Project Name: ALBUQUERQUE SOUTH UNIT 3

**Project# 1007504**

09DRB-70094 VACATION OF PUBLIC BLANKET DRAINAGE EASEMENT  
09DRB-70095 MINOR - PRELIMINARY/ FINAL PLAT APPROVAL

09DRB-70094 VACATION OF PUBLIC BLANKET DRAINAGE EASEMENT  
 09DRB-70095 MINOR - PRELIMINARY/ FINAL PLAT APPROVAL

PLAT OF
TRACT E-4-A-1
ALBUQUERQUE SOUTH
UNIT THREE

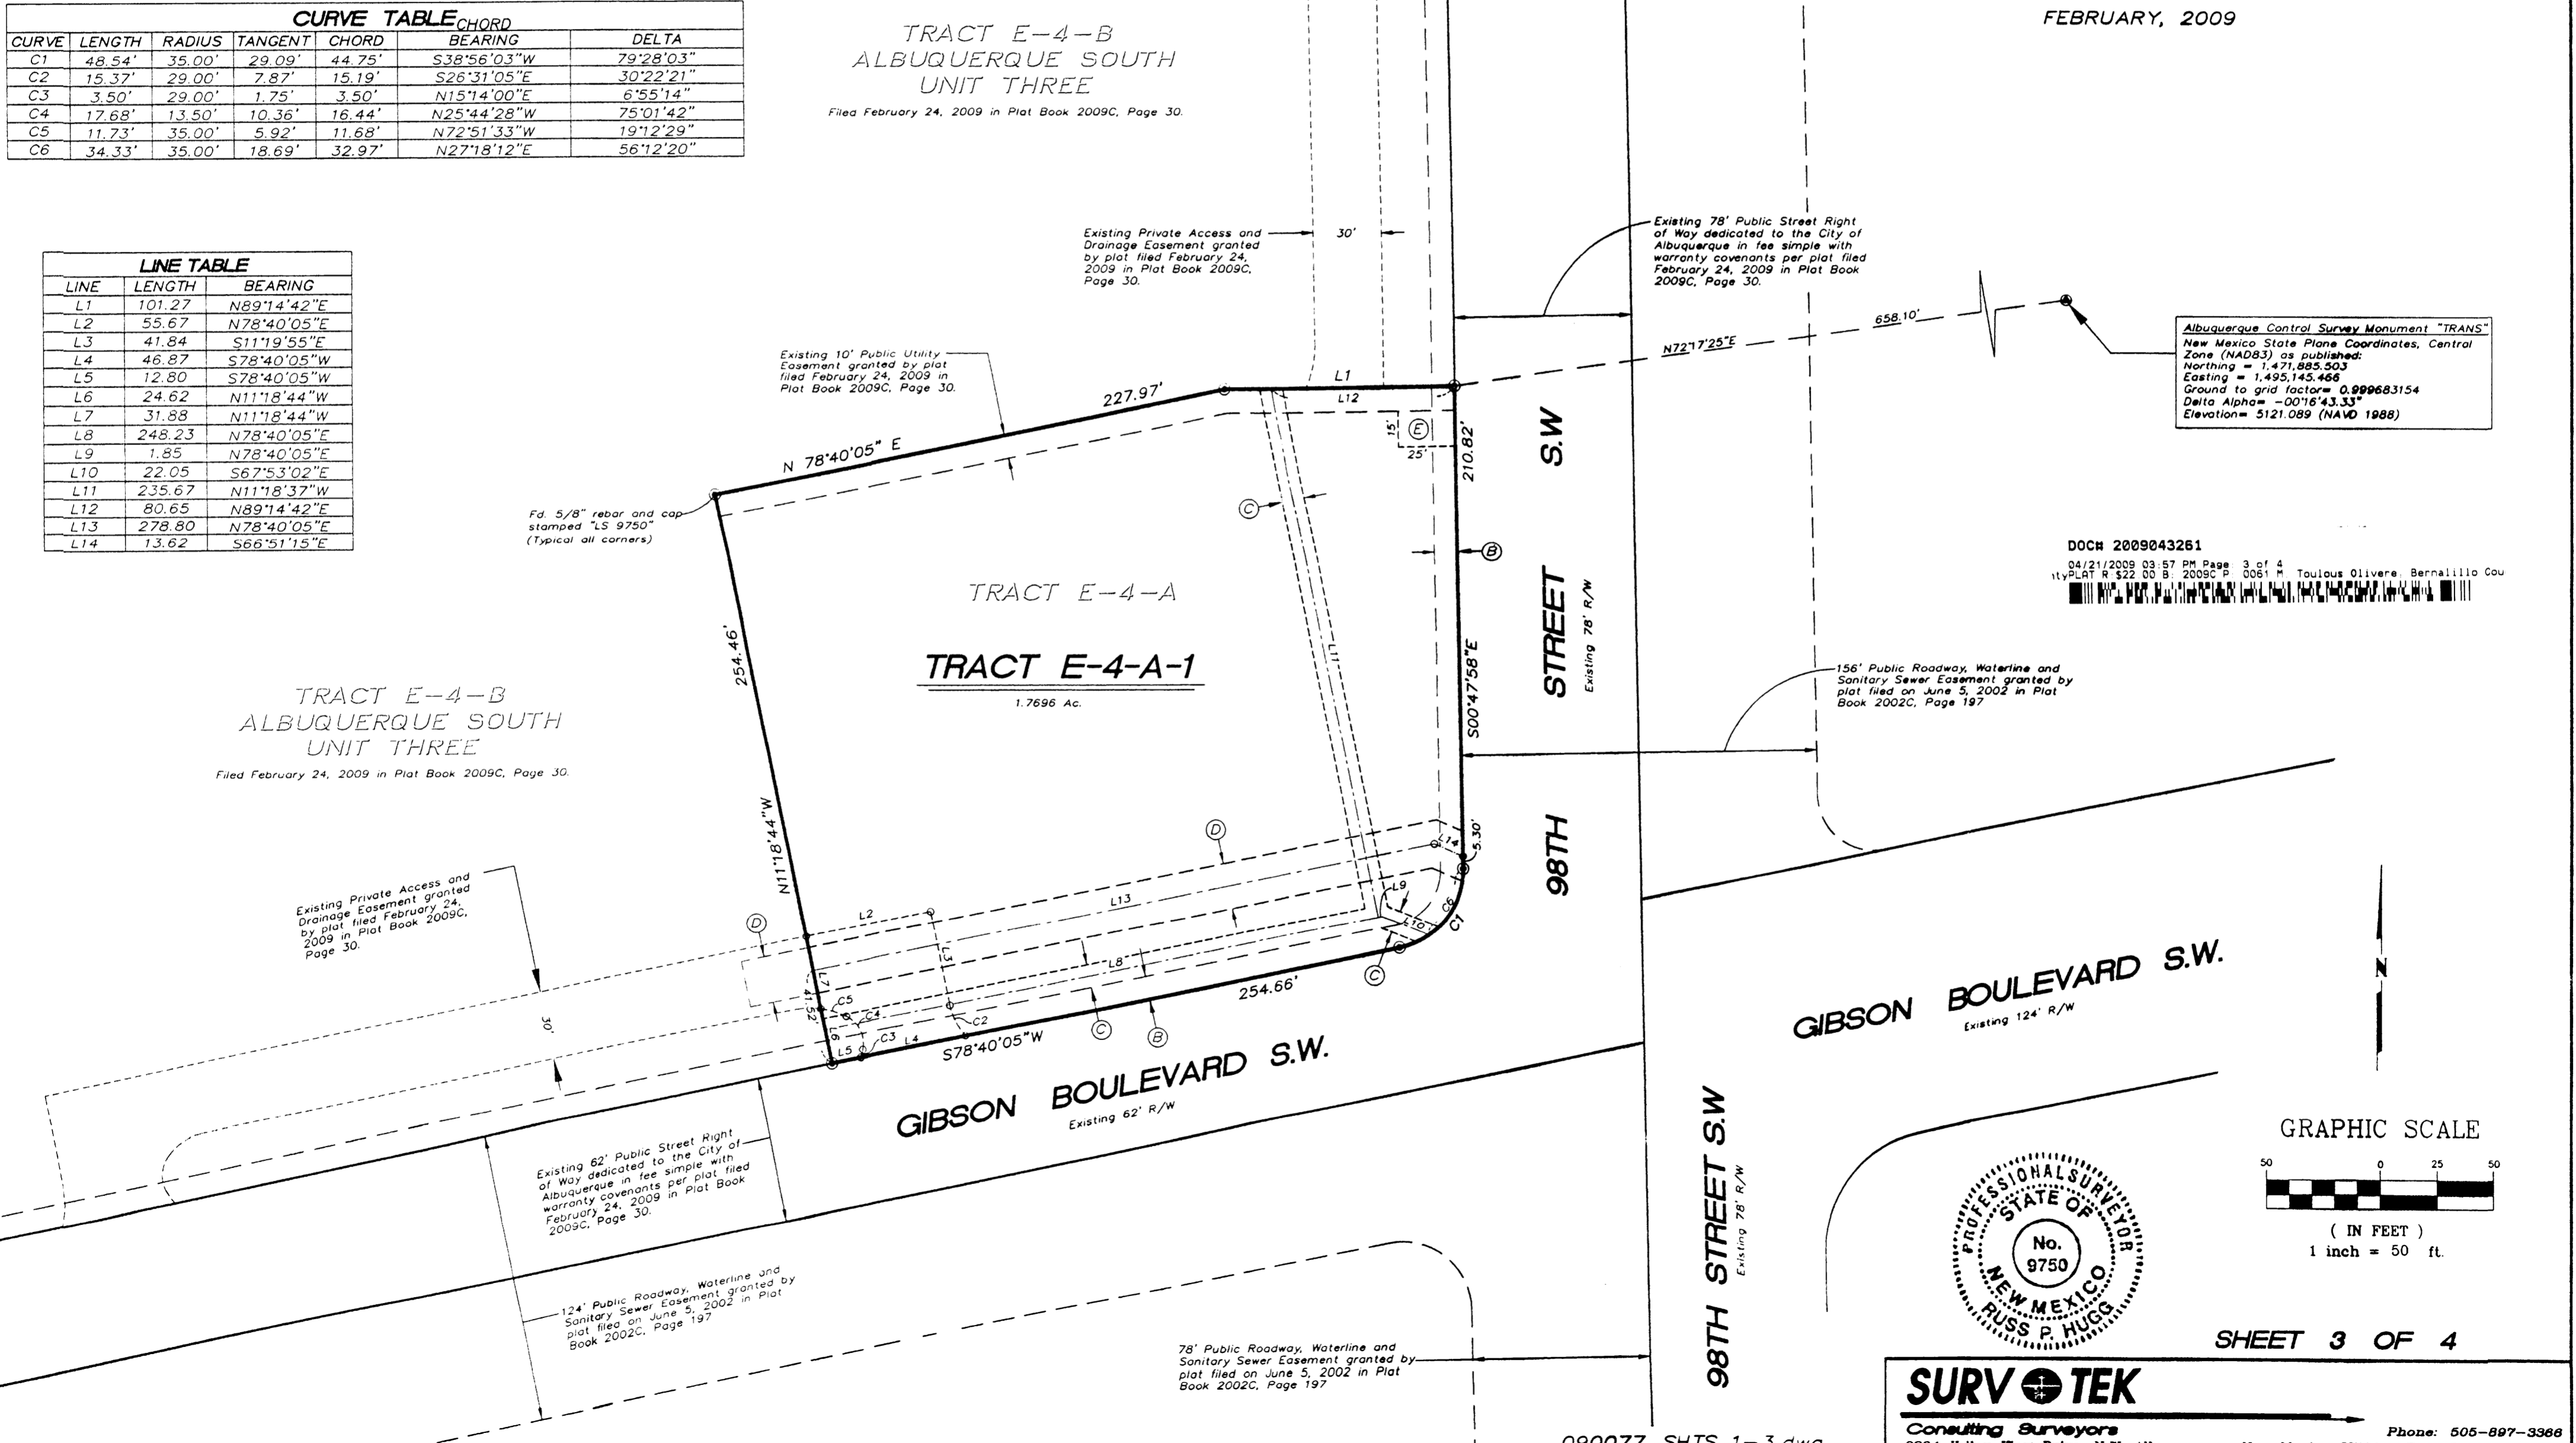
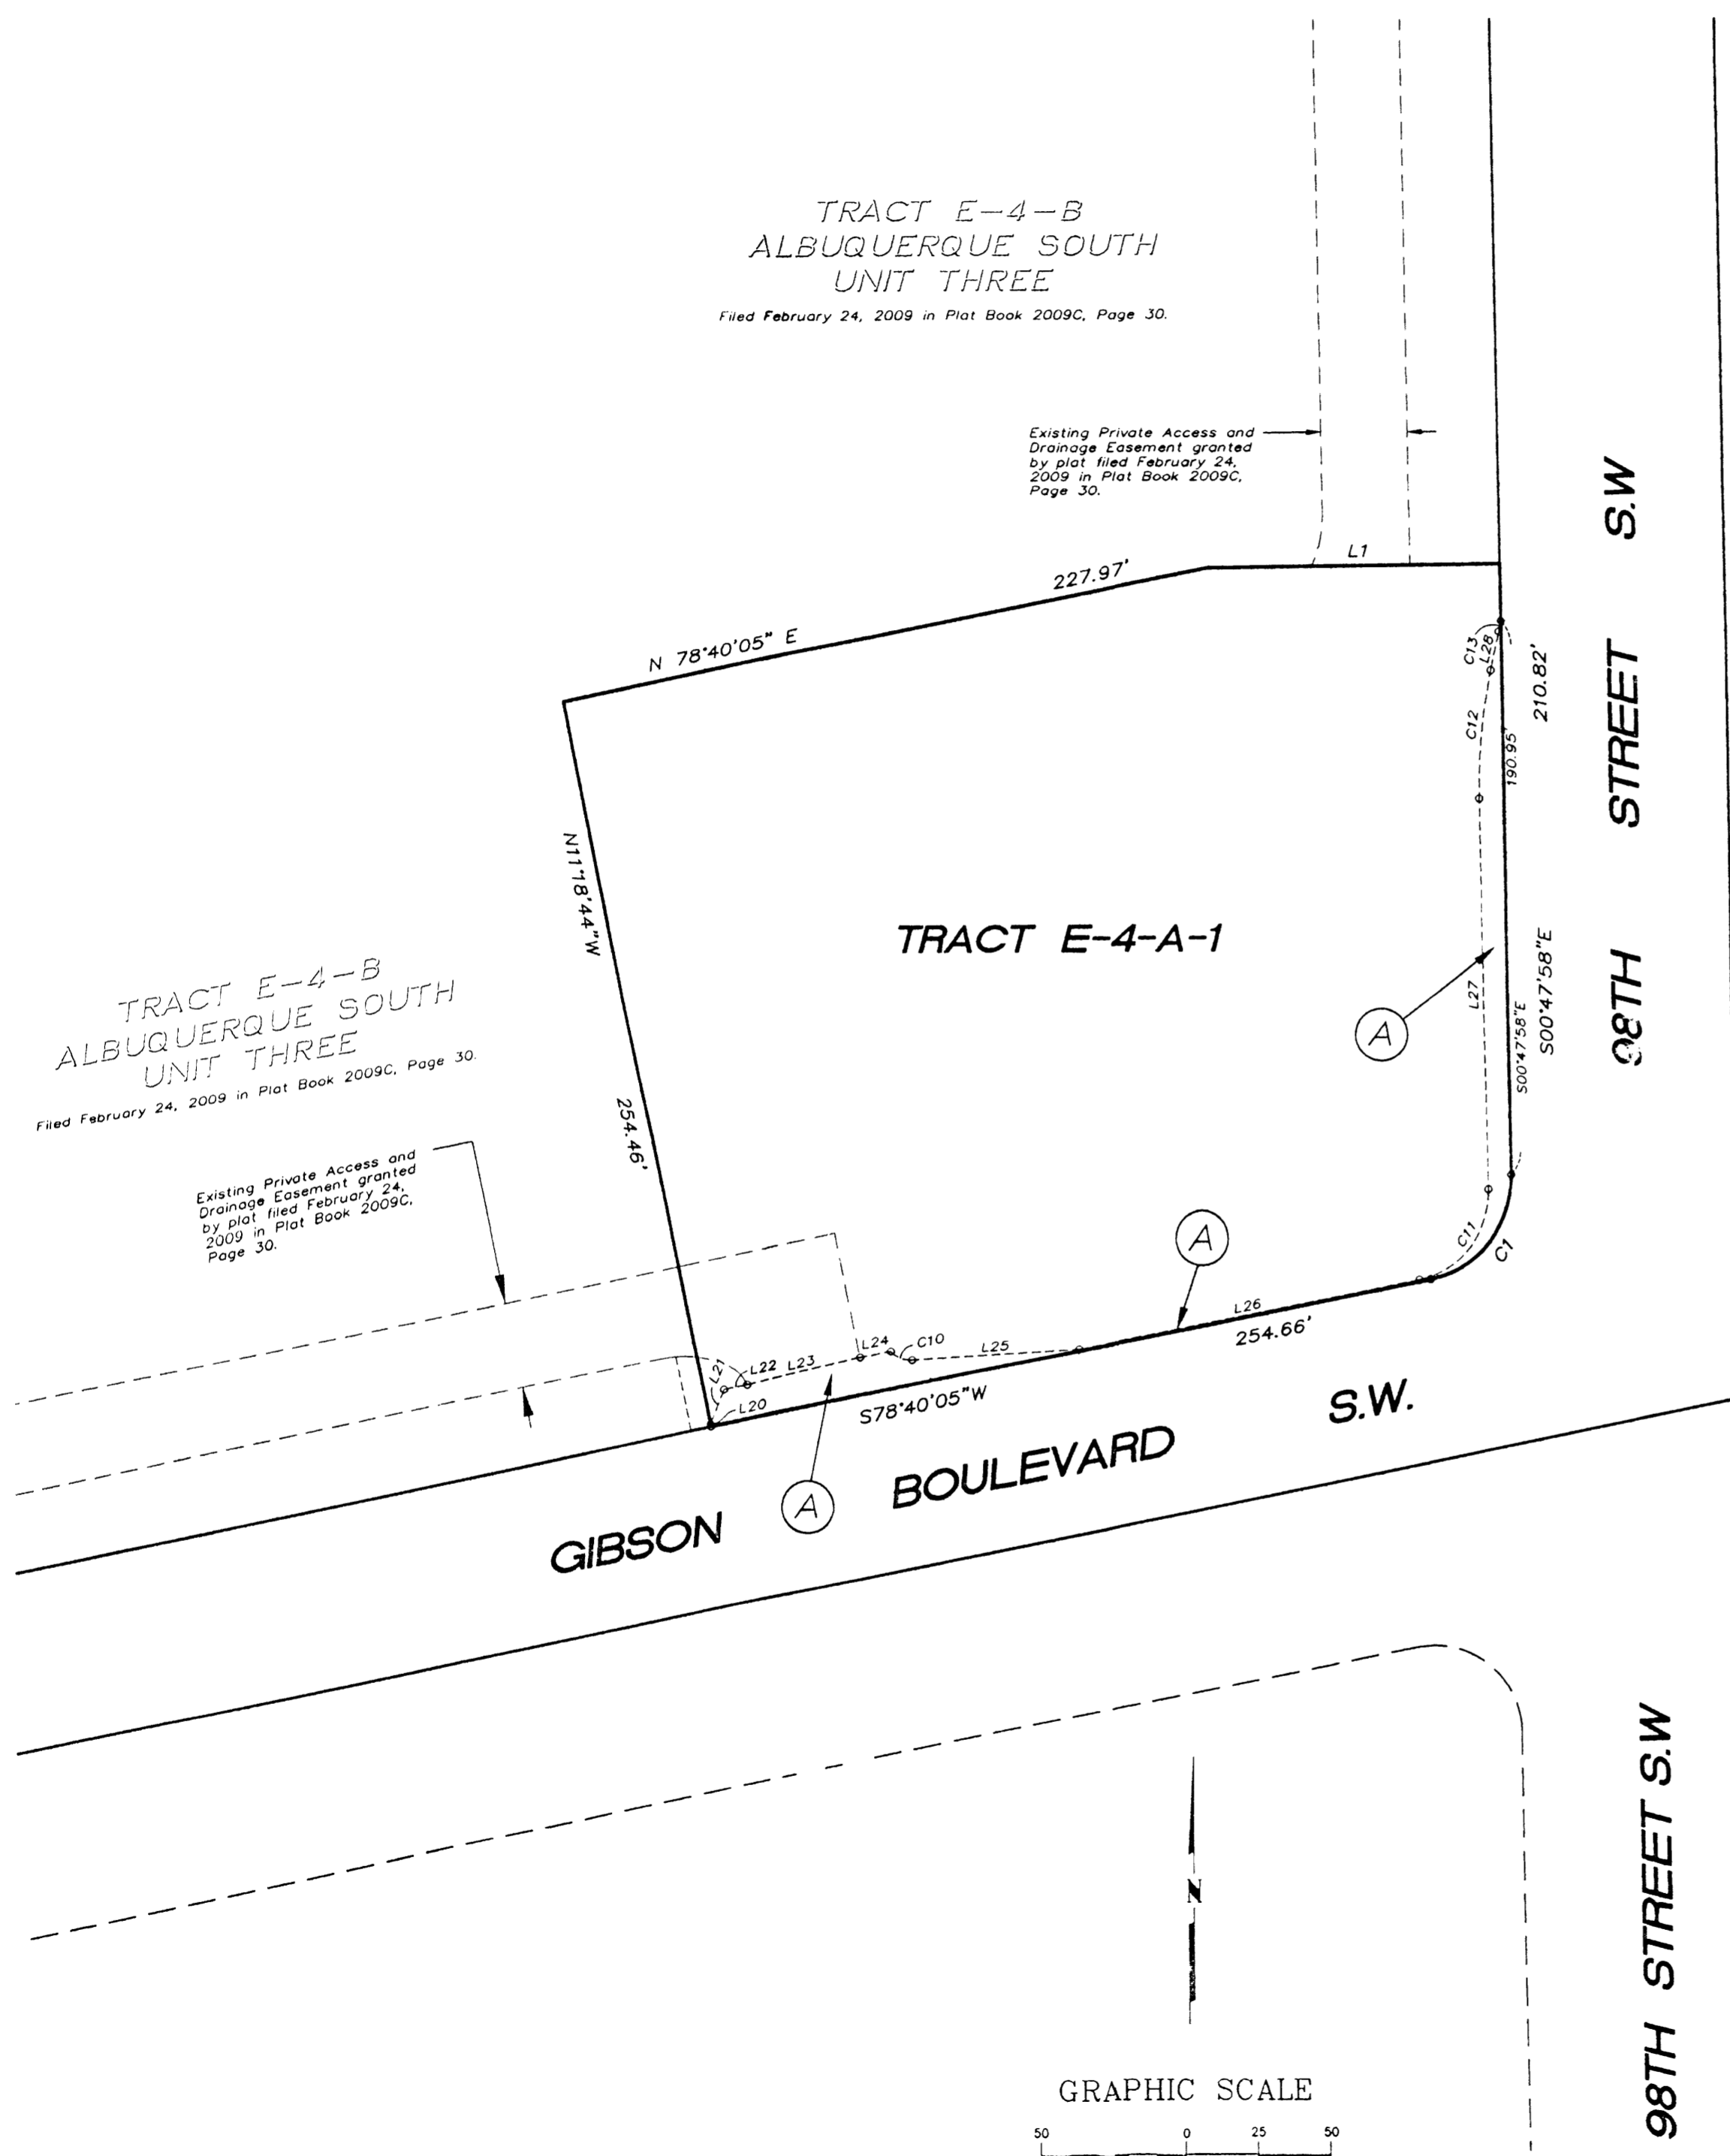
Gibson Blvd and 98<sup>th</sup> Street SW are principal arterial roadways in this area. As such, Table 23.2.1A of the *Development Process Manual* specifies that a 6 foot sidewalk with a 6-foot setback from back of curb is required. Based upon the information on file, additional dedication of right of way is required along 98<sup>th</sup> Street.

The right of way at the intersection of two arterial roadways requires a radius of 35 feet.
